Rezoning Transportation Analysis

Petition Number: #2022-091

| Date | Description |
|----------|-------------------|
| 11-28-22 | First Review (IW) |

RZ-1.0

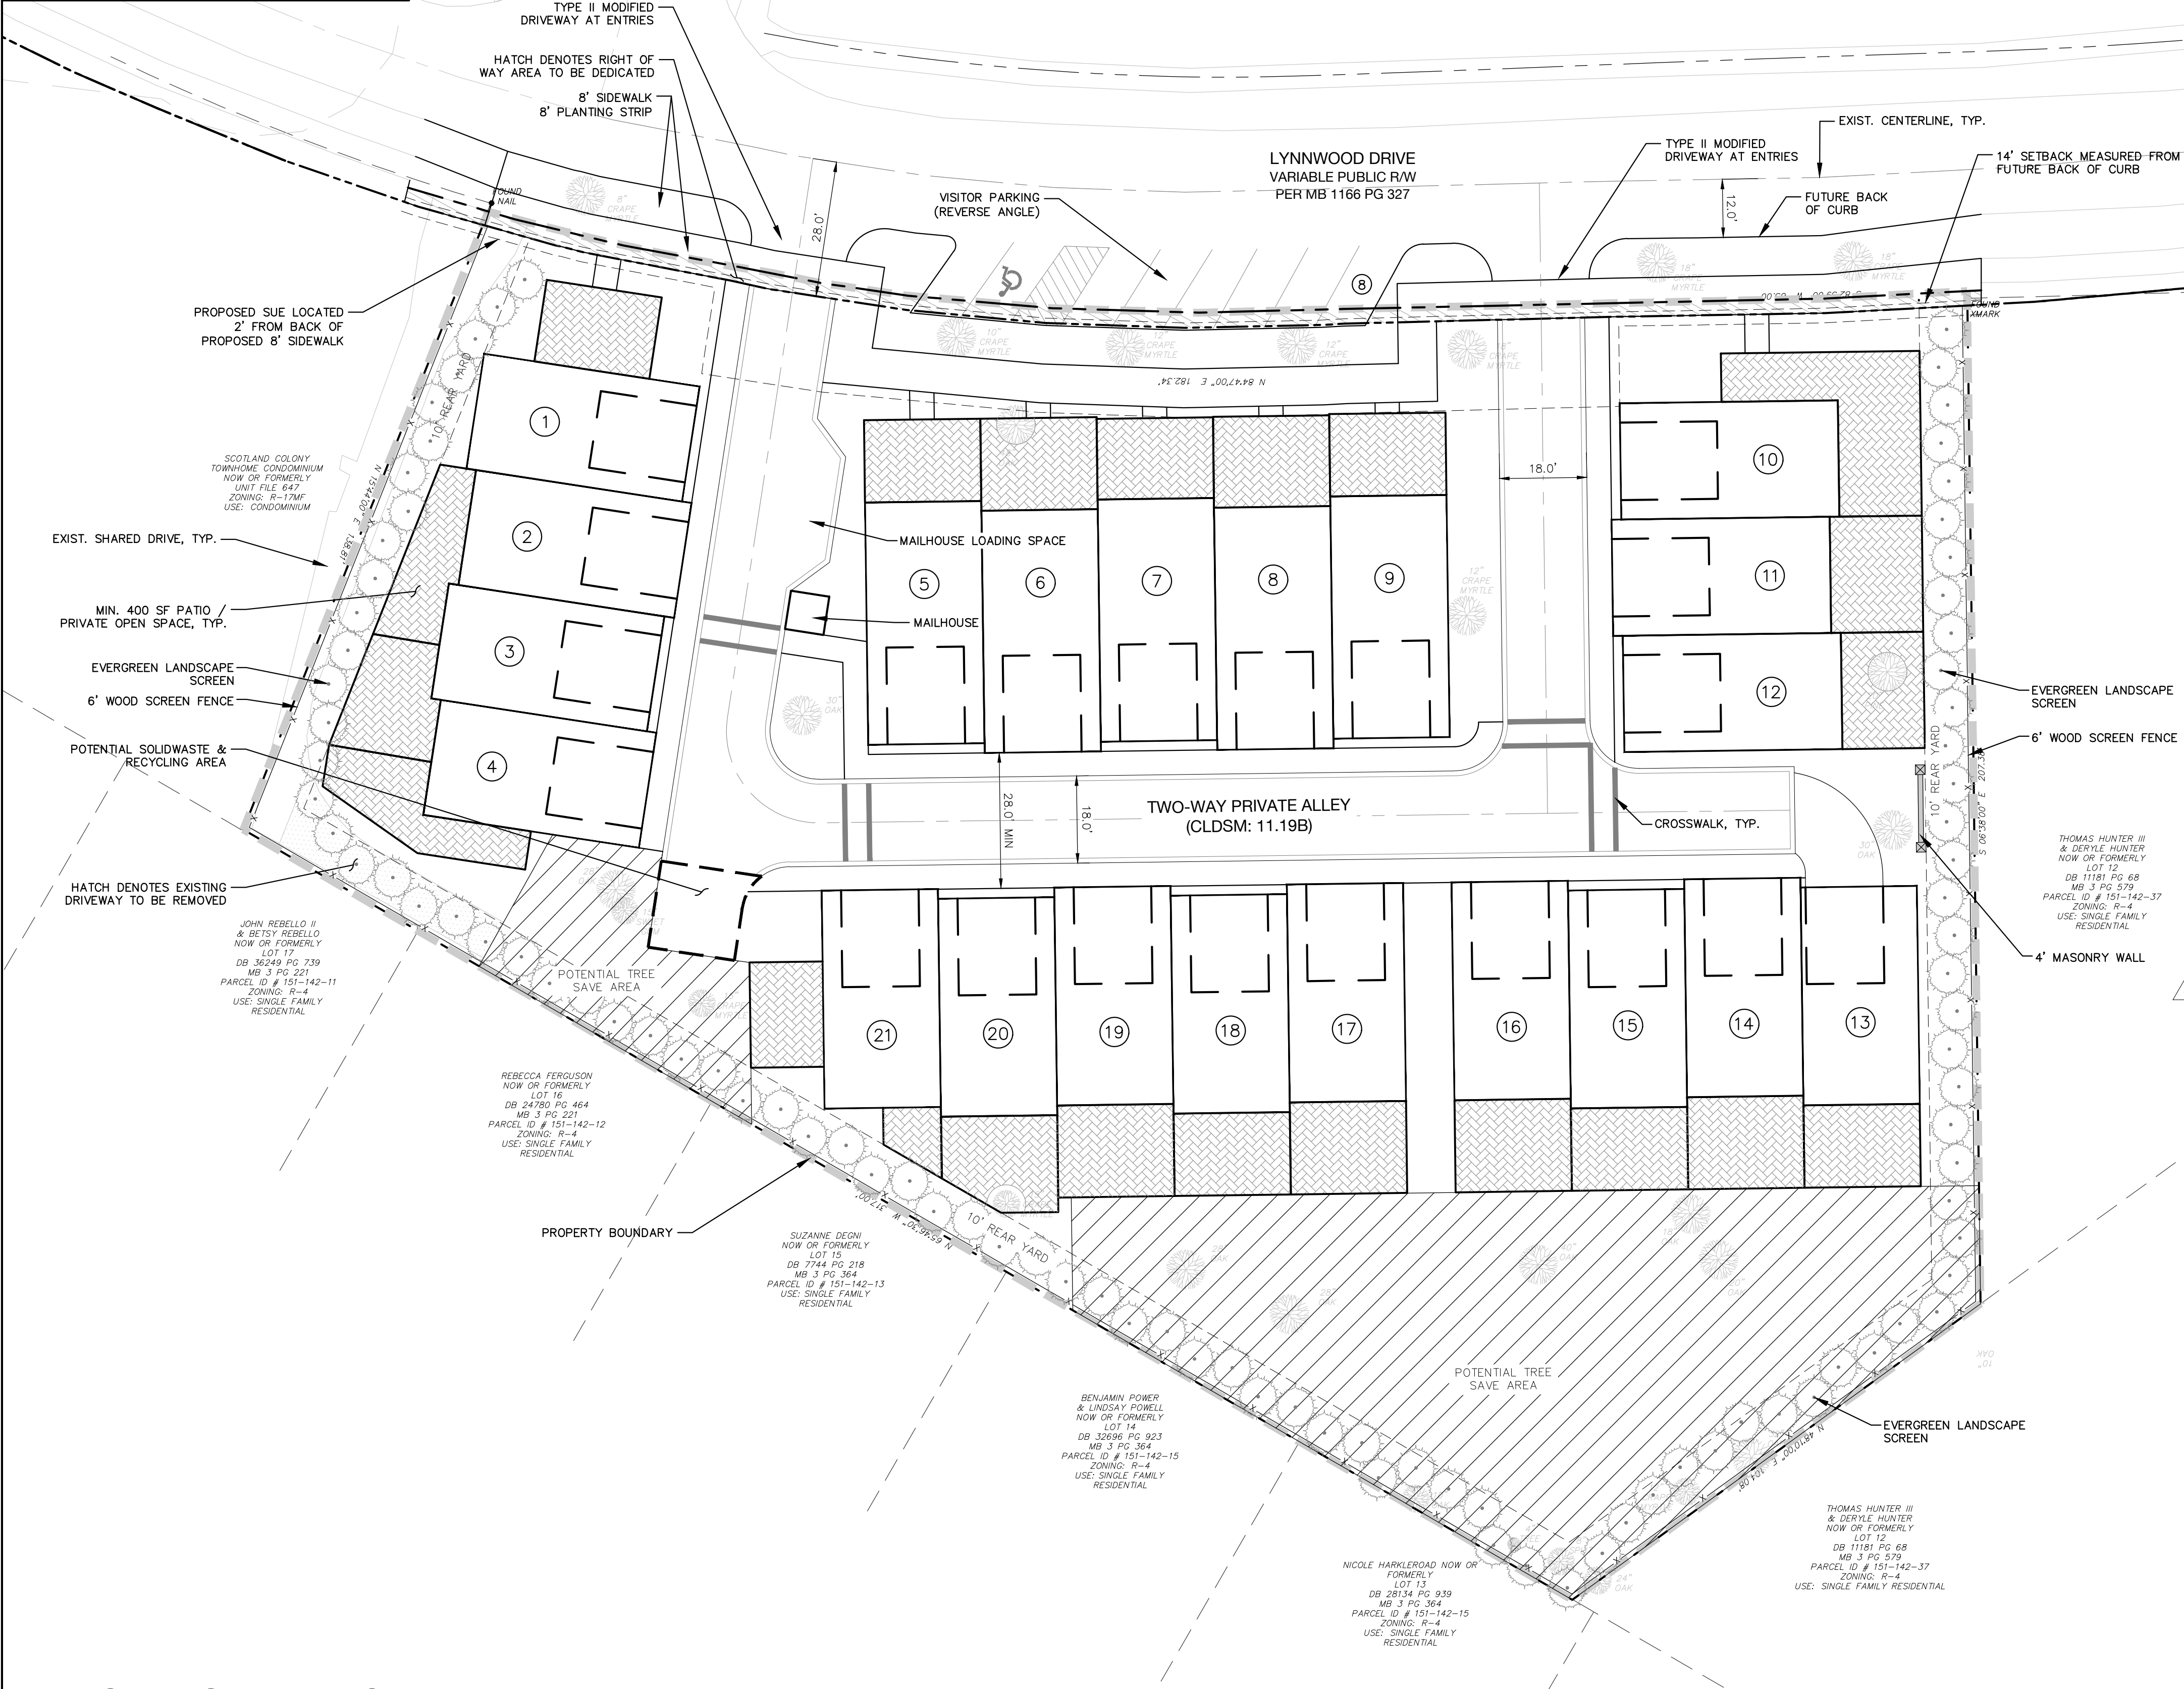
1. **Curbline:** The proposed zoning district has a setback measured from back of the existing or proposed future curbline.
 - a. **Lynnwood Drive:** The future location of curb and gutter should follow the CLDSM Local Residential Medium Street which is measured at 13-feet from the centerline of the roadway to the BOC.

Label and dimension the curb and gutter from the centerline for each road on the site plan.

3. Revise conditional note(s) to commit to dedicate 28-feet of right-of-way from the road centerline in coordination per CLDSM Local Residential Medium Street. The site plan shall label and dimension the right-of-way from the road centerline.
4. Revise site plan and conditional note(s) to remove angled parking and install parallel parking on Lynnwood Drive.
5. Revise site plan and conditional note(s) to call out driveway connection to public roadways as type II modified driveways 10.25E
6. Revise site plan and conditional note(s) to show 8-foot planting strip and 8'sidewalk extended to property line.

7. A site plan note(s) specifying dedication and fee simple conveyance of all rights-of-way to the City before the site's first building certificate of occupancy is issued as needed. CDOT requests rights-of-way set at 2' behind back of sidewalk where feasible.
8. Add conditional note "All public roadway improvements will be subject to the standards and criteria of CDOT and NCDOT, as applicable, to the roadway improvements within their respective road system authority. It is understood that such improvements may be undertaken by the Petitioner on its own or in conjunction with other development or roadway projects taking place within the broad north eastern Mecklenburg area, by way of a private/public partnership effort or other public sector project support."
